Your Ref: OWPC23194
Our Ref: LU/126/19/PL 16-04-2019
Please ask for:
Mrs A Gardner

Demolition of the existing garage building (B2 industrial use) and redevelopment of the site providing 9no C3 residential units - This application affects the character and appearance of River Road Conservation Area.

25 River Road Littlehampton

Thank you for your internet representation made on 27th May 2019 which has been recorded as **'an objection'** with the comments as follows:

PROPOSED DRAWINGS:
Terminus Place
Proposed & Existing Street Scenes

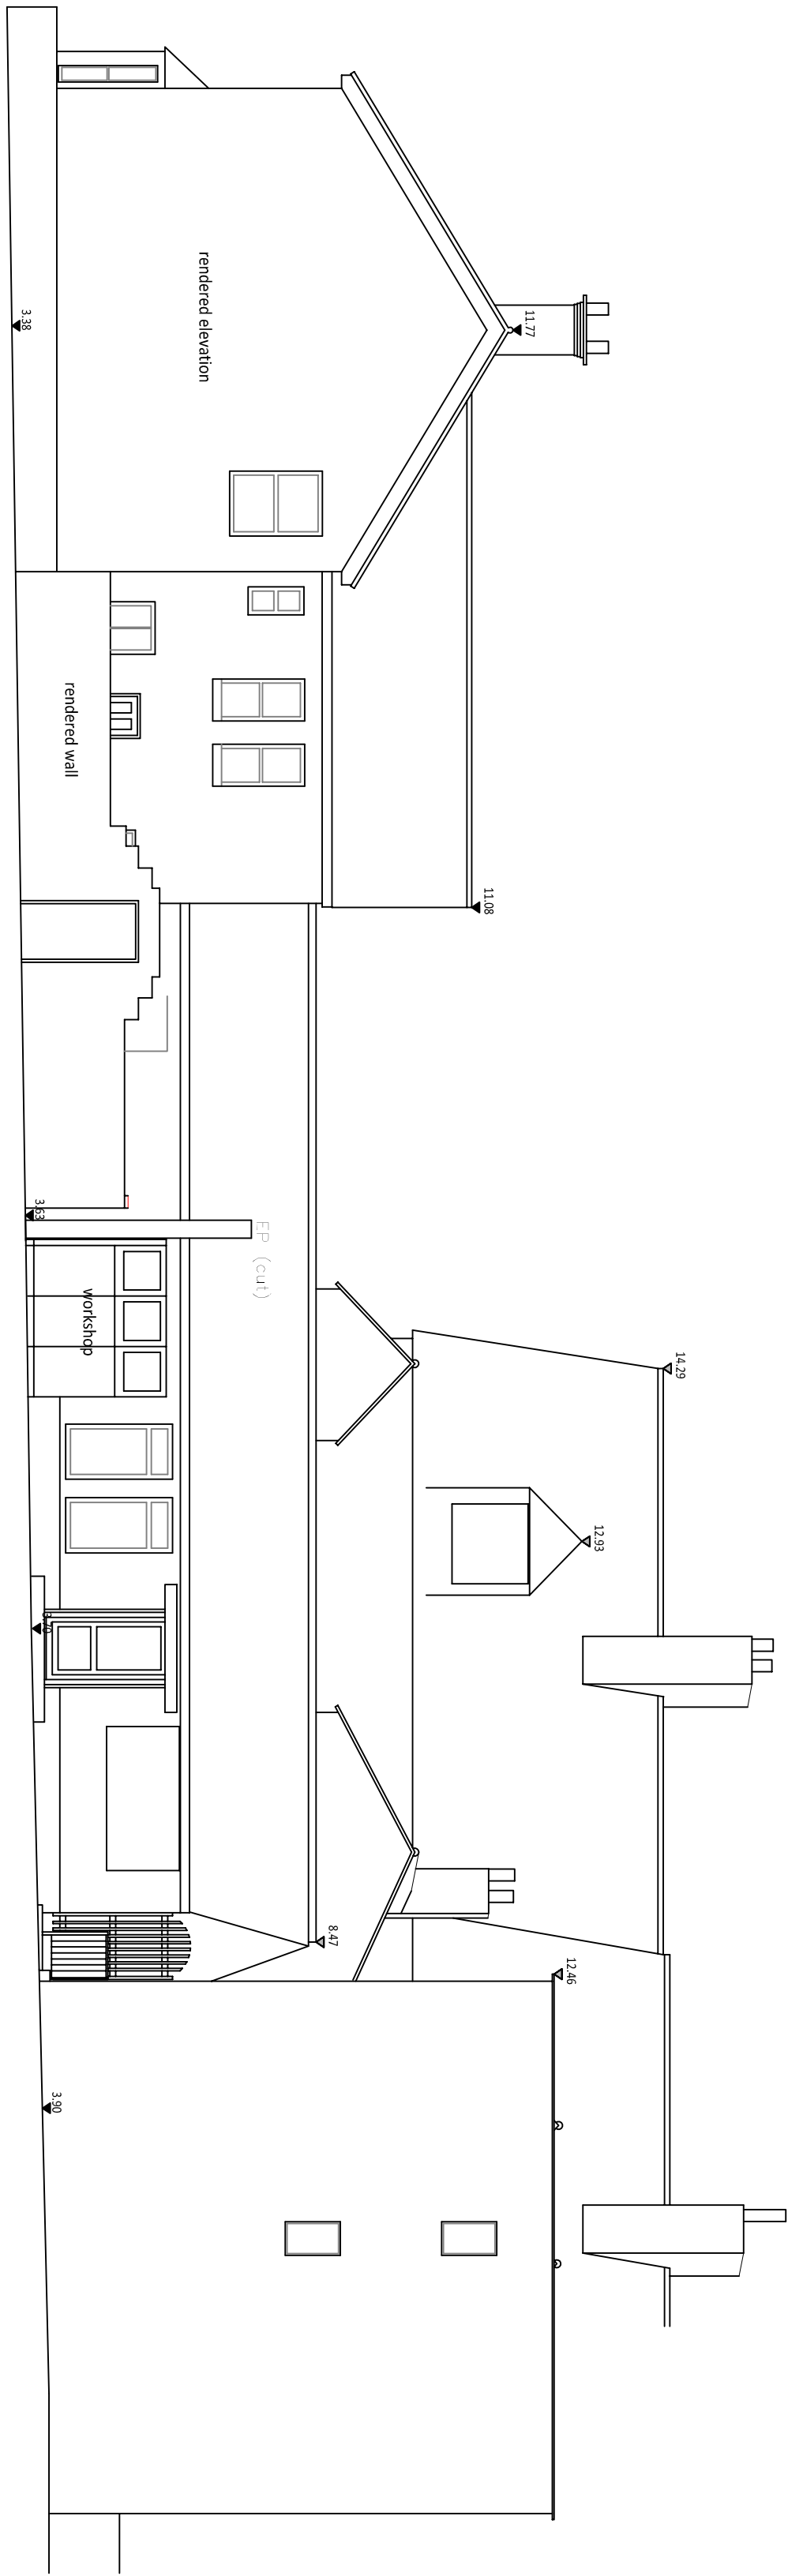
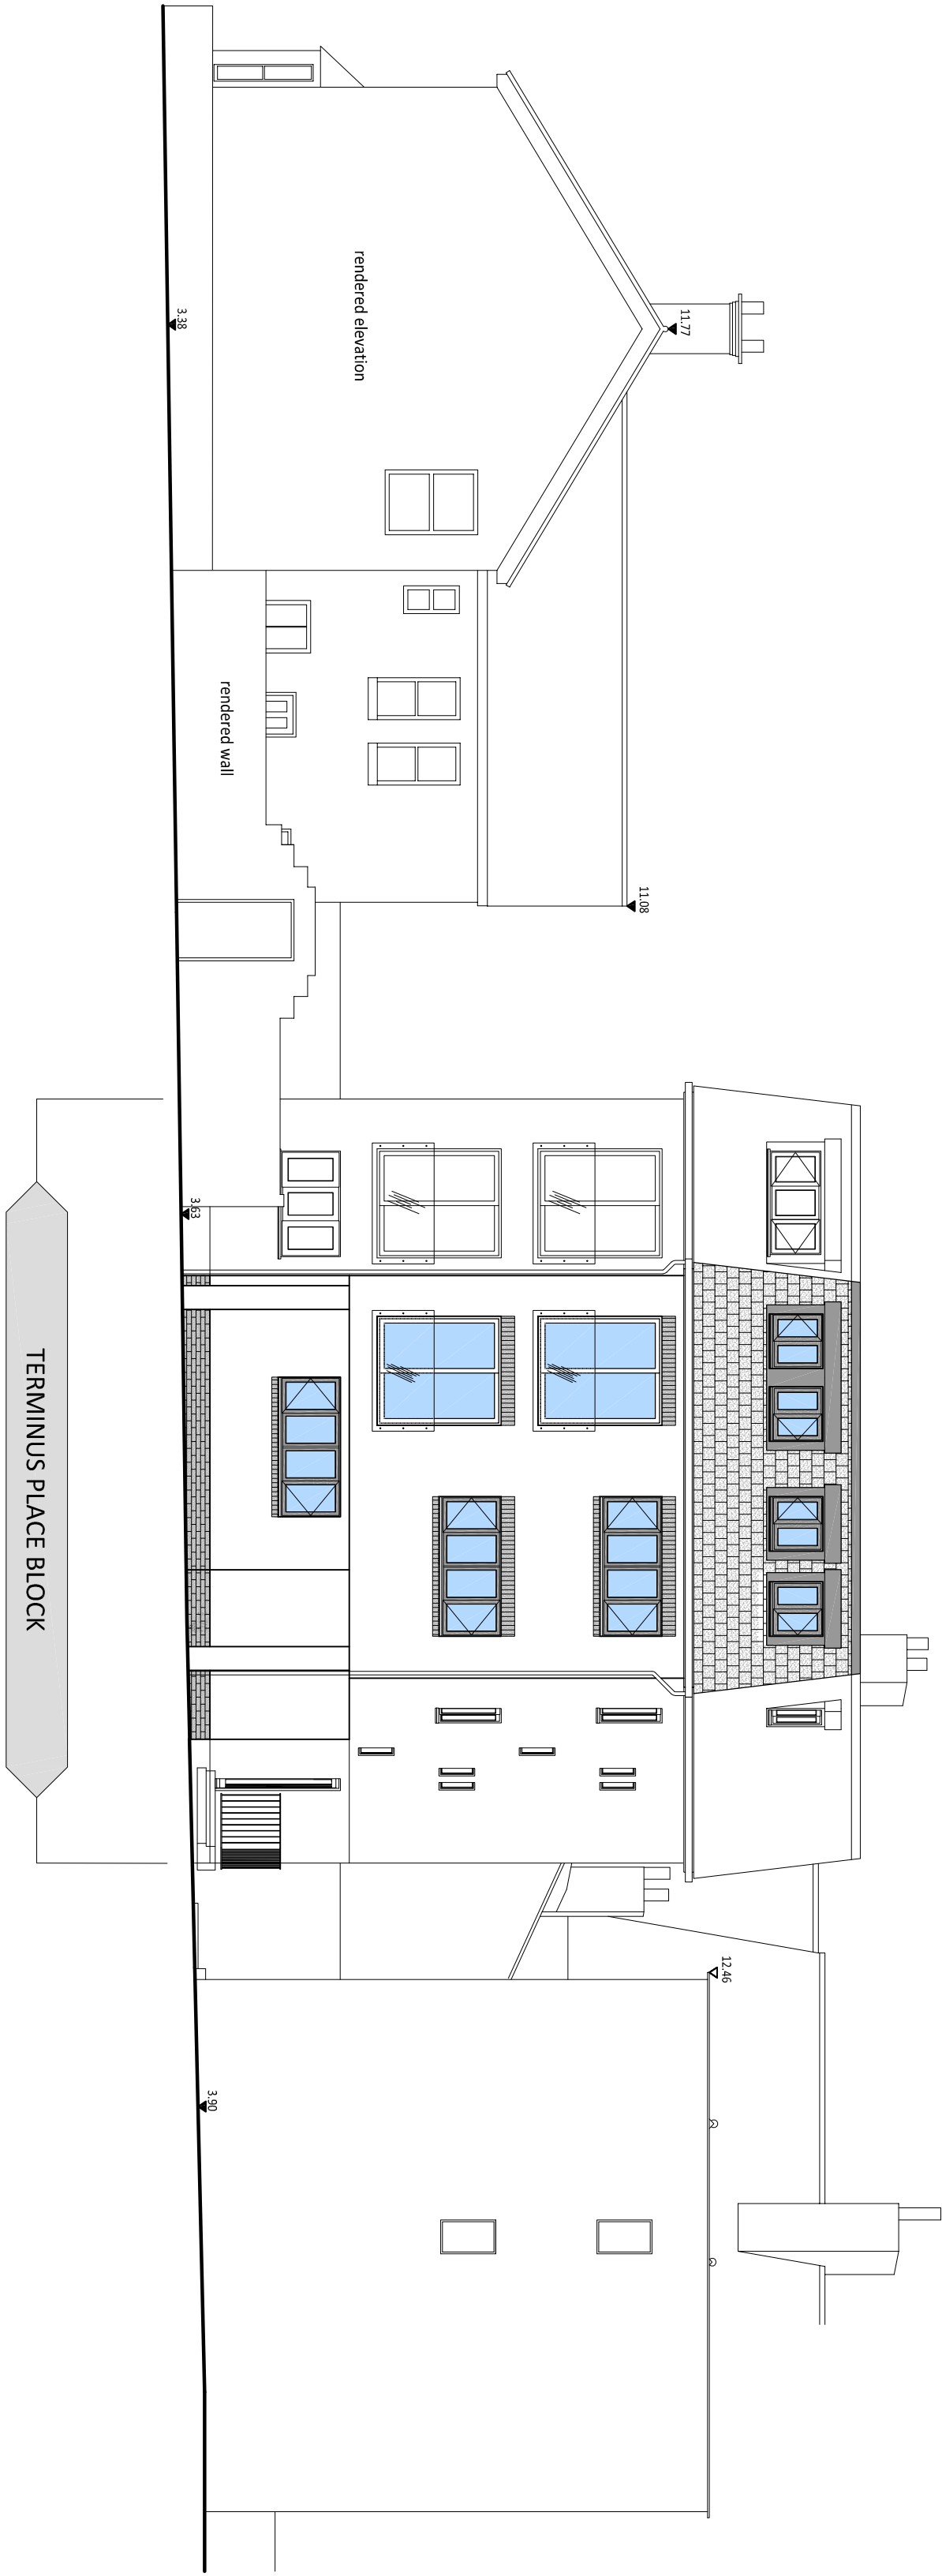
3. Terminus Road frontage - I object to due to the following

3a The height

3b It will have an impact on my privacy
